Application by National Grid Electricity Transmission for the Sea Link Project

Summary of East Suffolk Council's Relevant Representation on proposed changes (CR1) to the Sea Link Project

Deadline 3A Change request
(19 January 2026)

Application Ref.: EN020026

SUFFOLK REVISED ORDER LIMITS  
BENHALL RAILWAY BRIDGE

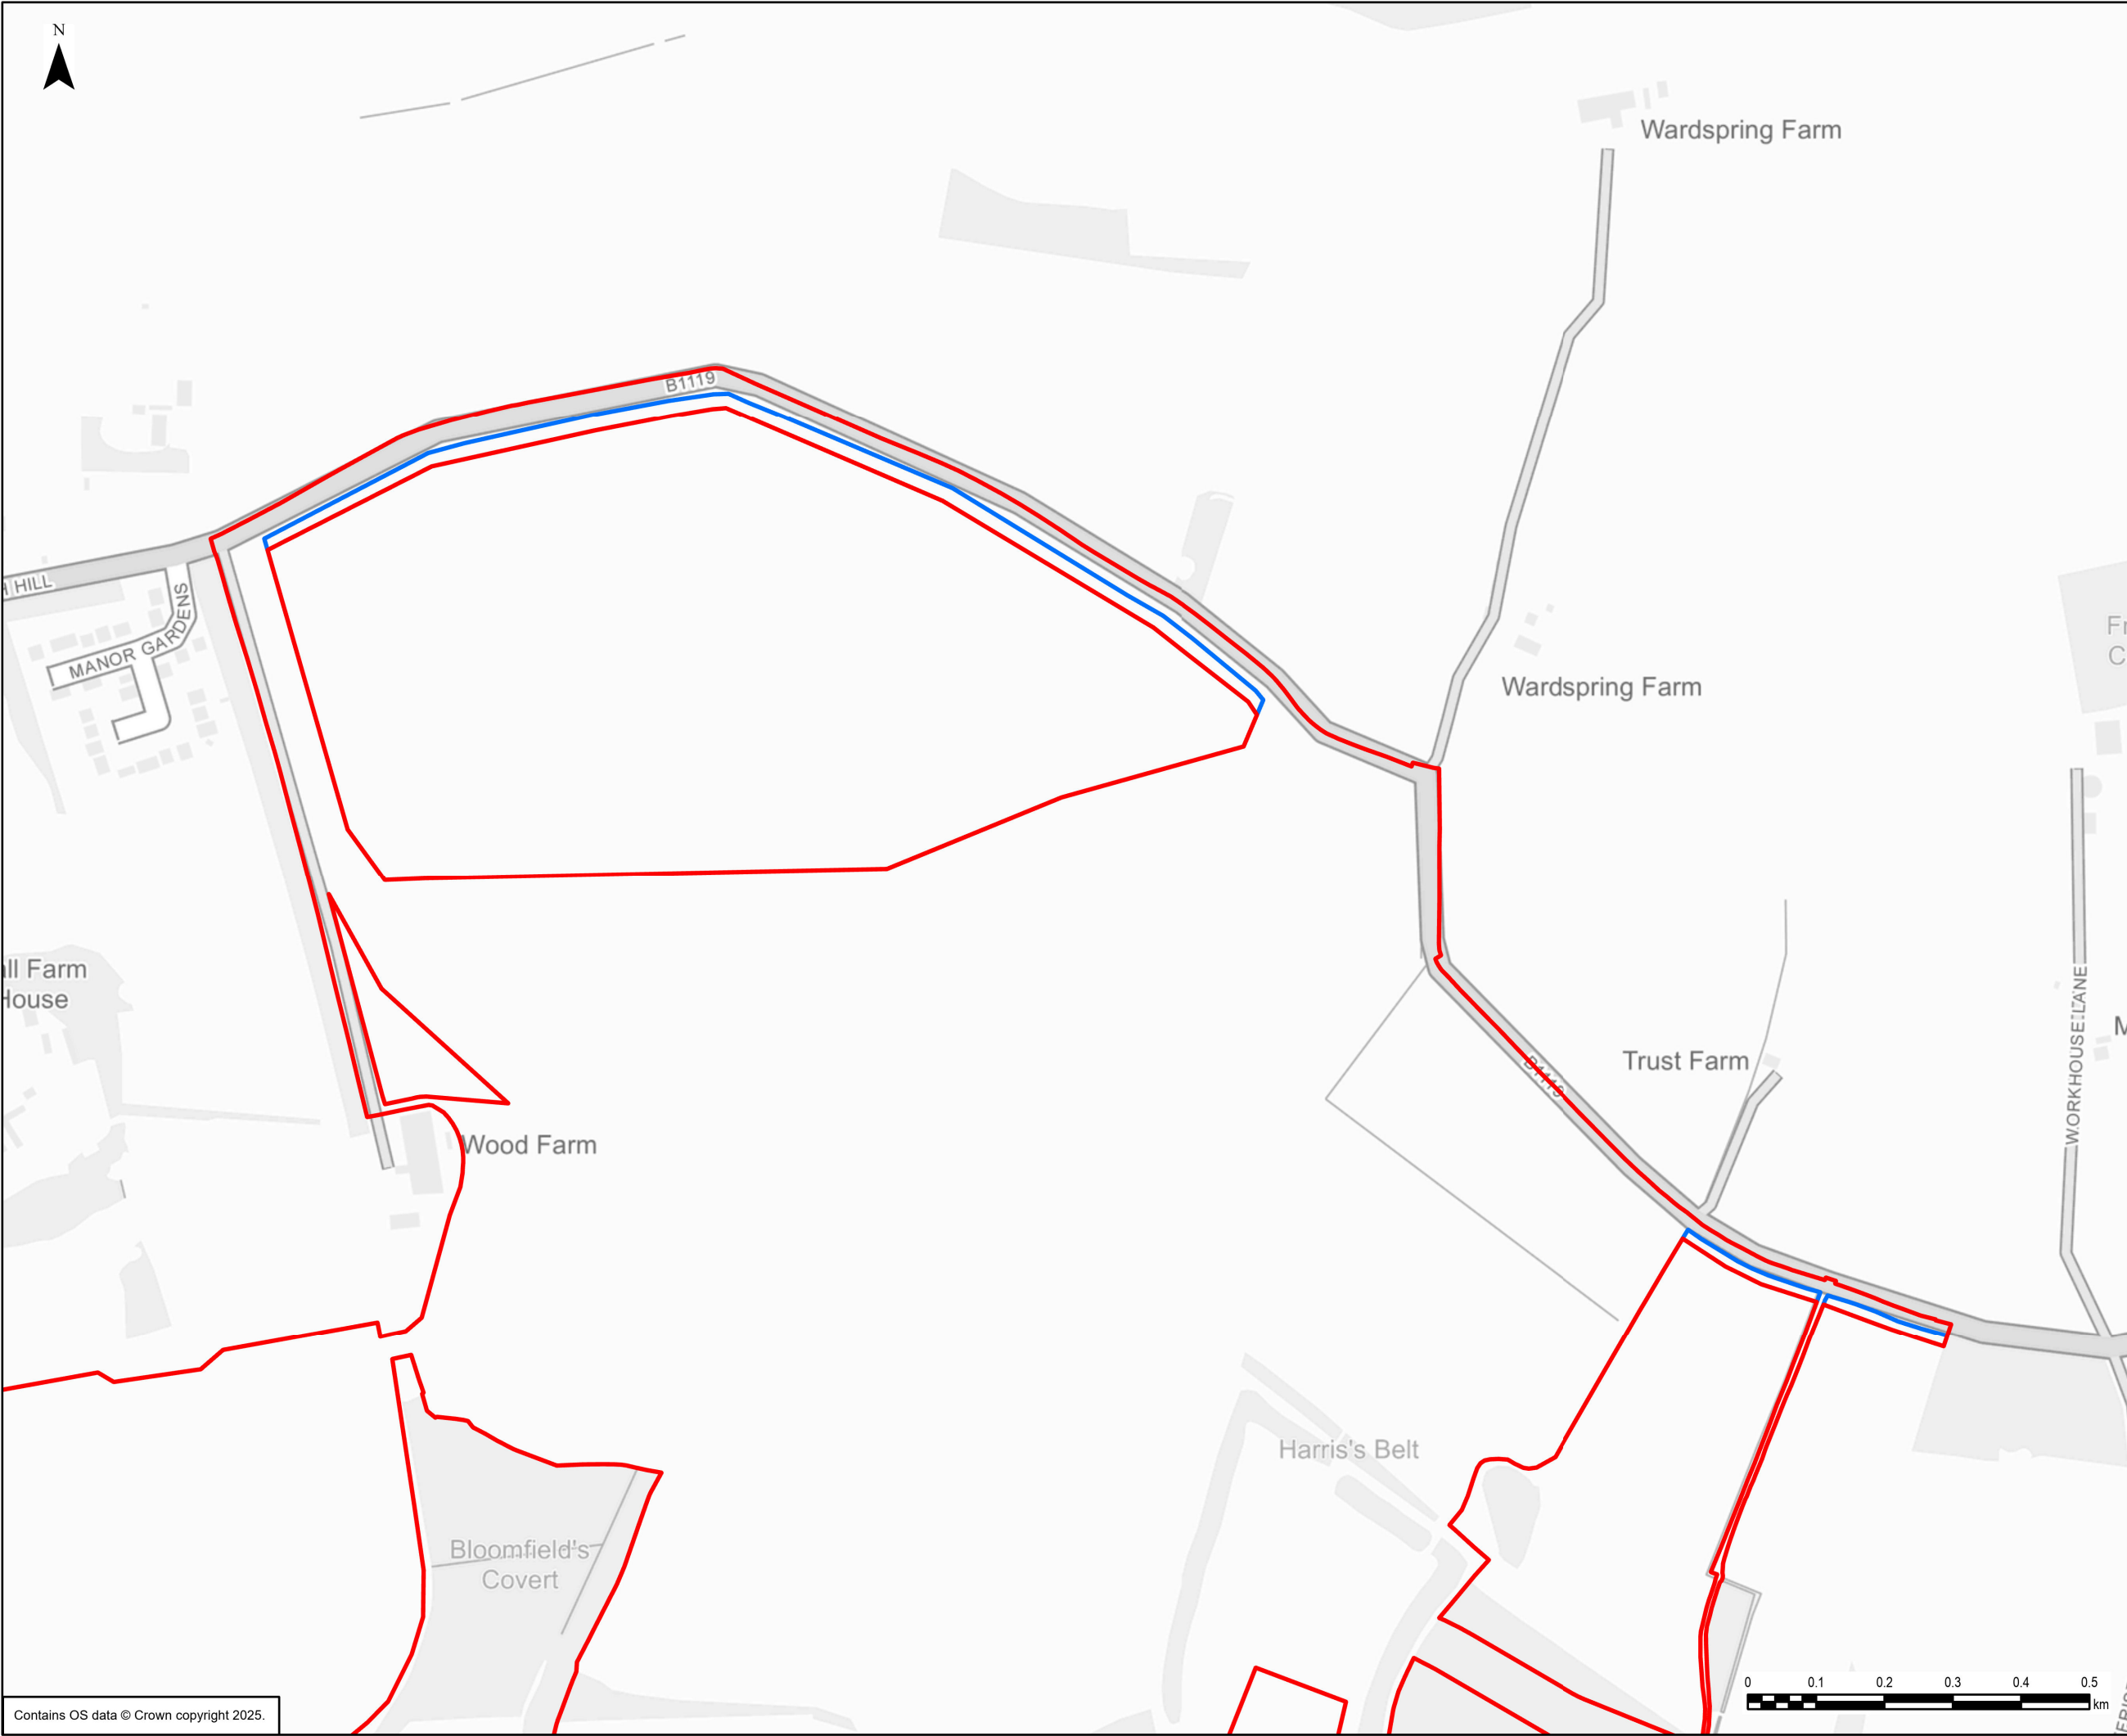
4. In relation to Change 4, ESC wishes to reiterate its concerns regarding the disruption that the Applicant's options to address the weight limit constraints of Benhall Railway Bridge would cause for the local community. ESC considers this disruption could have been meaningfully reduced had the Applicant sought to address the issue at an earlier stage.

5. ESC also questions where the Applicant is proposing to site the temporary construction compound now that the adjacent land consented for residential use cannot be included in the revised Order Limits. This detail is essential to provide ESC with confidence that Option 2 is deliverable in both practical and environmental terms.
